Ravensthorpe Homestead Complex – Glendell Continued Operations Project – Heritage Council comments on Response to Submissions Report (RTS) (Umwelt September 2020)

Heritage Council general comments 11 February 2020 on EIS.	Response to Submissions	Heritage Council review of RTS
<p>1. The Heritage Council endorsed the ICOMOS report, <i>'The Future of Our Pasts: Engaging cultural heritage in climate action'</i> in 2019 and is committed to ensuring long term protection and conservation of our cultural heritage through the good practice, adaption and mitigation advice it provides and the actions it recommends.</p>	<p>No response has been provided to the Heritage Council general comments.</p>	<p>No response is required.</p>
<p>2. The Heritage Council considers that Ravensthorpe Homestead and its surrounding cultural landscape is likely to be of state heritage significance for its aesthetic, historic, scientific and social values.</p>	<p>The revised statement of significance within the RtS is consistent with this comment.</p>	<p>The revised statement of significance is considered adequate.</p>

Figure 16: 500m Homestead Offset Conceptual Final Landform

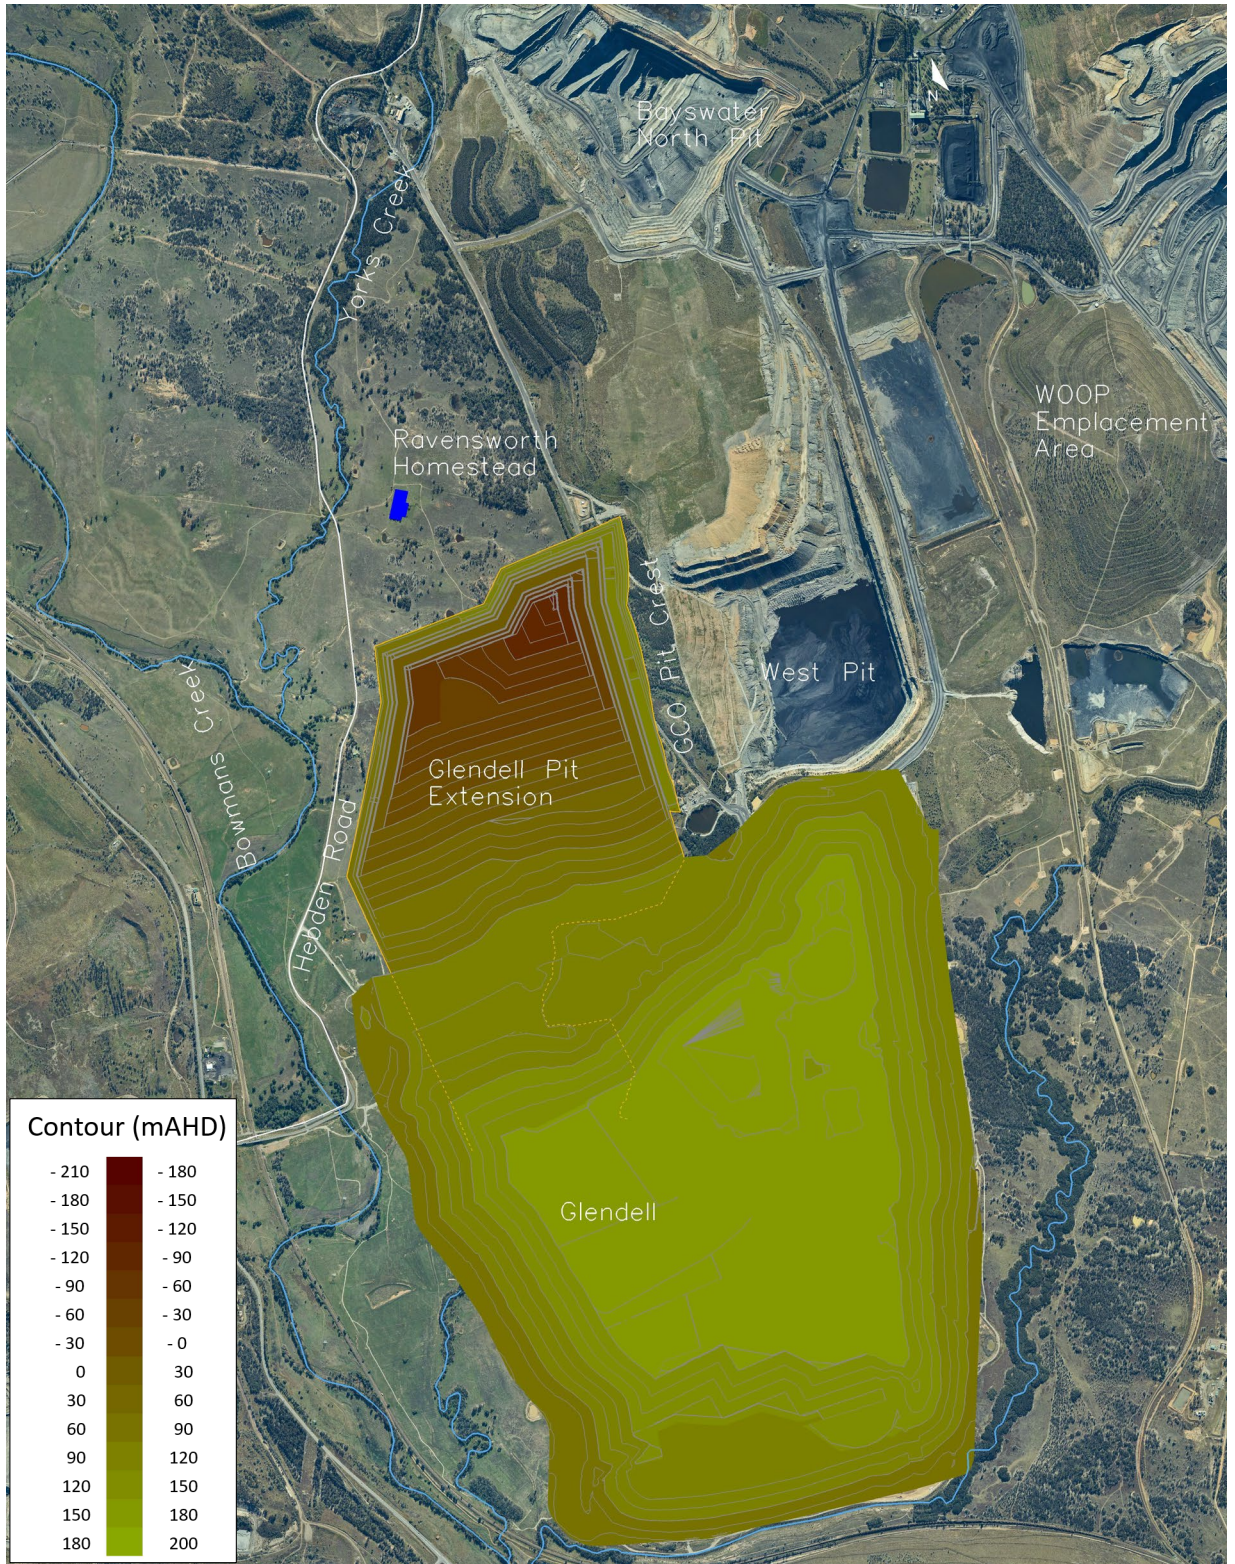
<p>f) <i>an analysis of all reasonable and feasible options to preserve the Homestead (including leaving in situ);</i></p> <ul style="list-style-type: none"> The EIS has not adequately met the requirements of this SEAR as it has not provided an analysis of all reasonable and feasible options to preserve the 	<p>RTS Page 47 No additional information provided. The options of mining to a distance of 900m (southern boundary of Core Estate Lands) and 500m (acceptable blasting vibration on the building and removal of</p>	The HC disagrees with the premise that all alternatives to the entire site being utilised, that were not considered financially viable, should be discarded.

<p>Homestead (including leaving in situ) or an adequate justification of why Options 6, 7 and 8 are not possible to ensure that Ravensworth Homestead is not impacted by the proposed works.</p>	<p>potential flyrock damage) to the south of the Ravensworth Homestead was not considered commercially viable for Glencore.</p> <p>The analysis concludes that the Project requires the development of the full mining area as proposed, in order to achieve a return on investment. If approval was given for an alternative mining footprint that leaves the Ravensworth Homestead in situ, then it is highly unlikely that Glencore would proceed with the Project which would have significant local, regional and State economic impacts.</p> <p>Glencore believes that the proposed mining footprint and associated relocation of Ravensworth Homestead provides an appropriate balance between the competing interests of mining and economic benefits to NSW, and the conservation of heritage values (p48).</p>

Figure 20: Ravensworth Farm

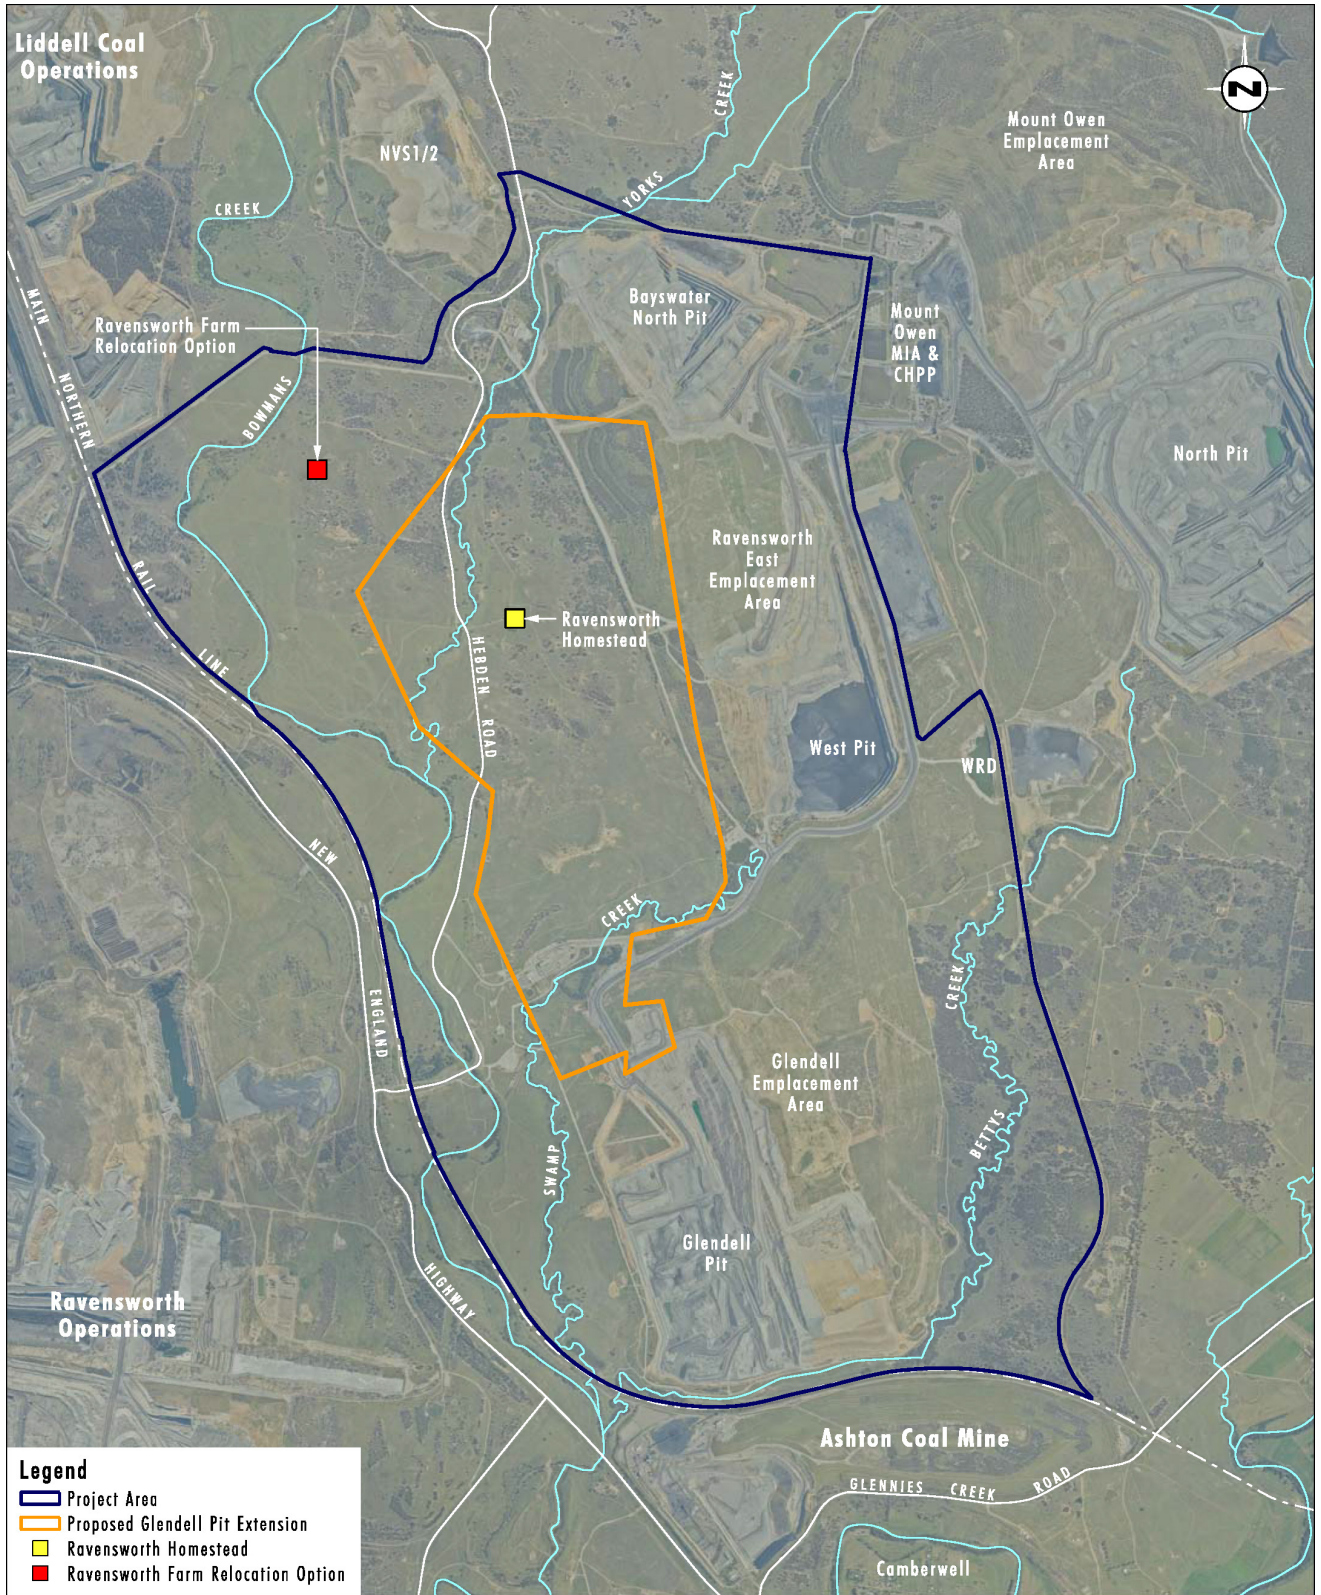
<ul style="list-style-type: none"> • Insufficient information has been provided for Option 1 regarding the presence of underground mining under the recipient site and the likely blasting vibrations impacts on the relocated structures from existing adjacent mines. 	<p>RTS Page 61 Following review of subsidence impact assessment and design information for the homestead provided post EIS, Subsidence Advisory NSW has subsequently provided approval conditional on adoption of recommended subsidence mitigation strategies as a precautionary approach, which includes:</p> <ul style="list-style-type: none"> • Development of a subsidence management plan • Development and implementation of a monitoring plan across the existing site pre-relocation to identify long term trends • Monitoring of the structure post-relocation • Slab and foundation design to consider potential settlement mechanisms <p>The vibration limits are expected to increase for the relocated Homestead due to significant improvements to building foundations completed as part of the relocation. Until new vibration limits have been confirmed, the current Mount Owen Consent criteria will continue to apply to the Homestead.</p>	<p>HC considers that there is uncertainty in the assessment of impacts from vibration limits from adjacent Mount Owen mine, that are in the vicinity of Ravensworth Farm.</p>

Figure 14: Ravensworth Homestead Location and Ravensworth Farm Relocation Site

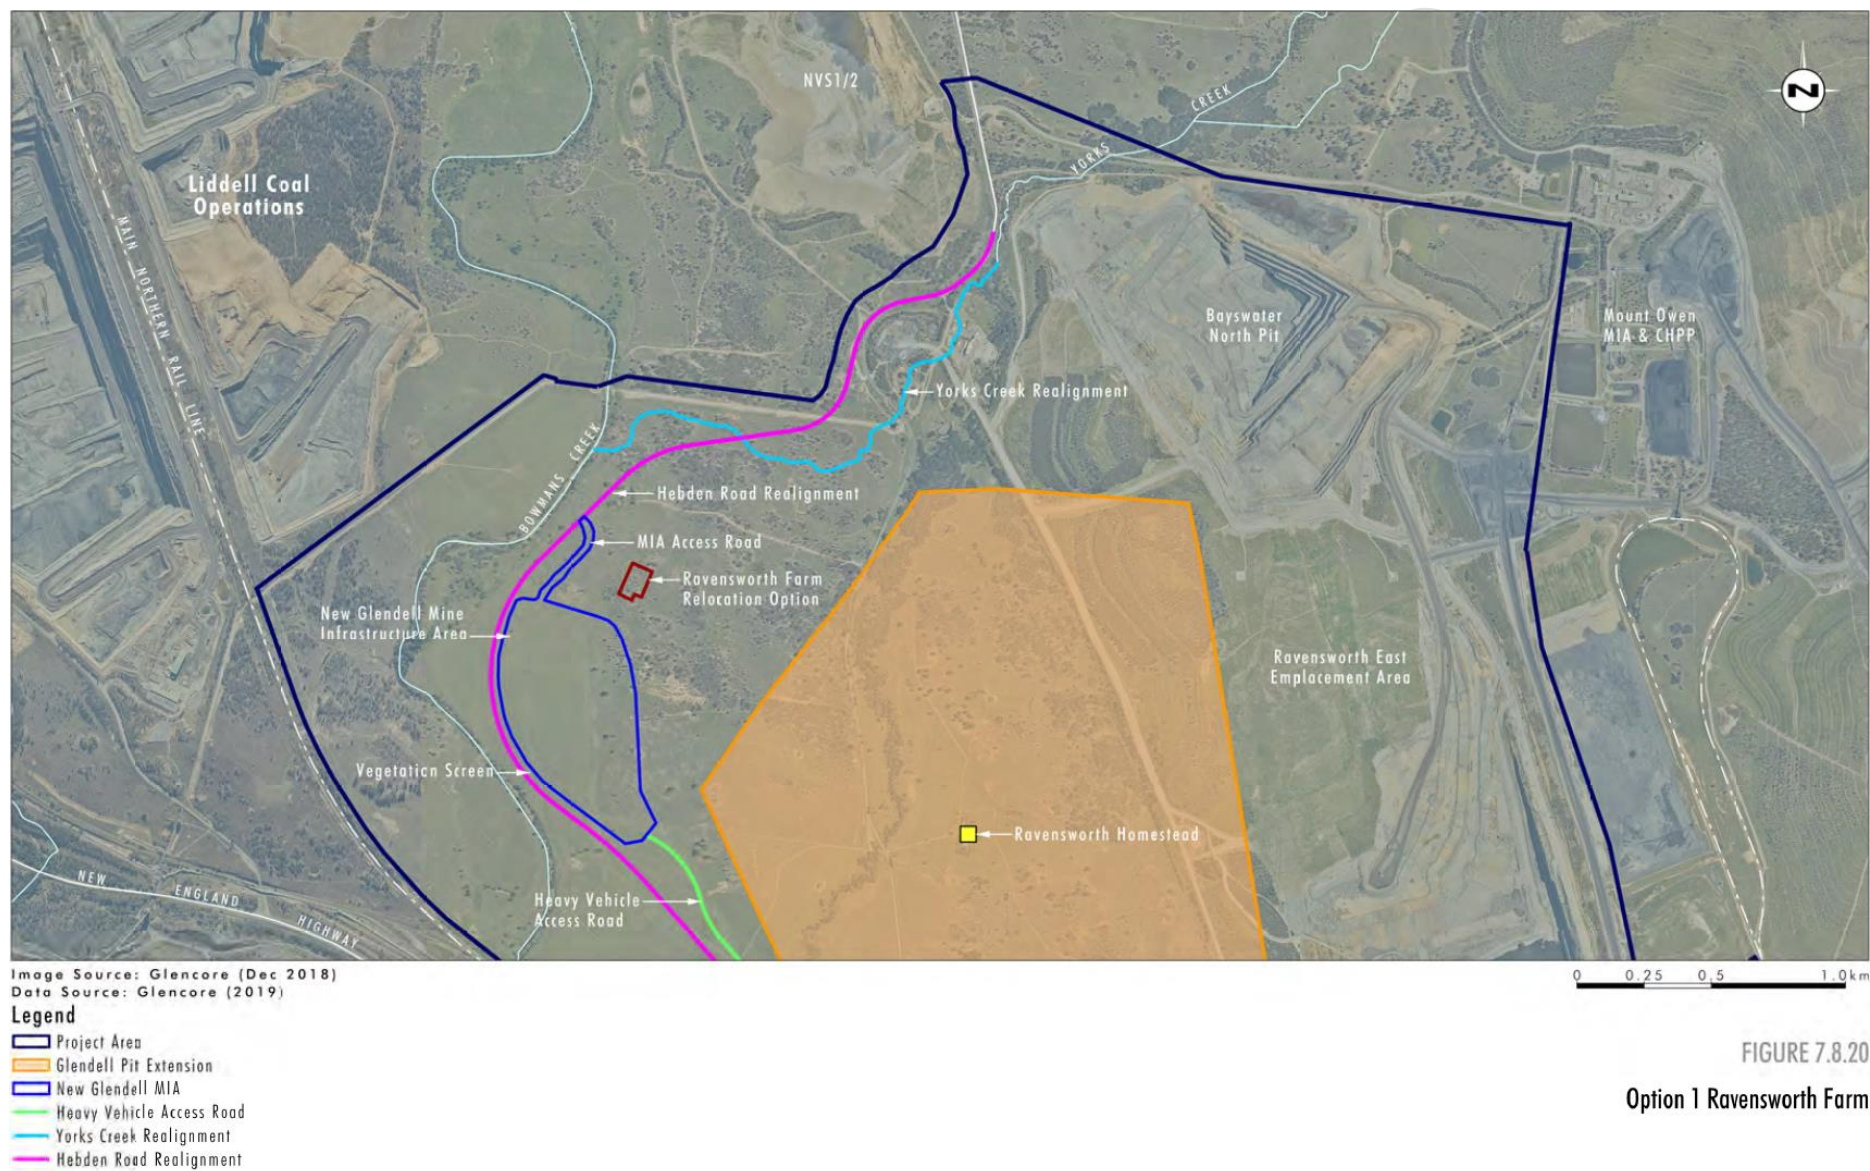
<p>g) <i>if relocation is selected as the preferred option, please include an analysis of all feasible relocation options...</i></p> <ul style="list-style-type: none"> This SEAR has not been met. The proposed options for relocation are not considered to have been appropriately met as neither option provides for the full relocation of the entirety of Ravensworth Homestead without demolition or removal of significant fabric such as the 1920s addition and the original homestead footings. Much more detailed information needs to be provided before either option can be considered. 	<p>Glencore disagrees with the statement that this SEAR has not been met.</p> <p>RTS Page 48 Glencore have undertaken extensive research and investigation to select two reasonable and feasible options are proposed as part of the EIS.</p> <ul style="list-style-type: none"> Ravensworth Farm (Option 1) – involves the intact relocation of all buildings including moving selected trees and plants to the ‘Ravensworth Farm’ site located within the Project Area and on the original Bowman “10,000 acre” land grant (Ravensworth Estate Lands). Broke Village (Option 2) – this is a proposal put forward to Glencore by members of the Broke-Fordwich community and involves the dismantling all of the Homestead buildings and relocation to Broke where the buildings would be rebuilt and have multi-purpose usage forming the village square. 	<p>HC disagrees. Neither option provides for the full relocation of the entirety of Ravensworth Homestead without demolition or removal of significant fabric such as the 1920s addition and the original homestead footings.</p> <p>Each option is considered inappropriate as they will result in the diminishing or loss of most Ravensworth the State significant values.</p>
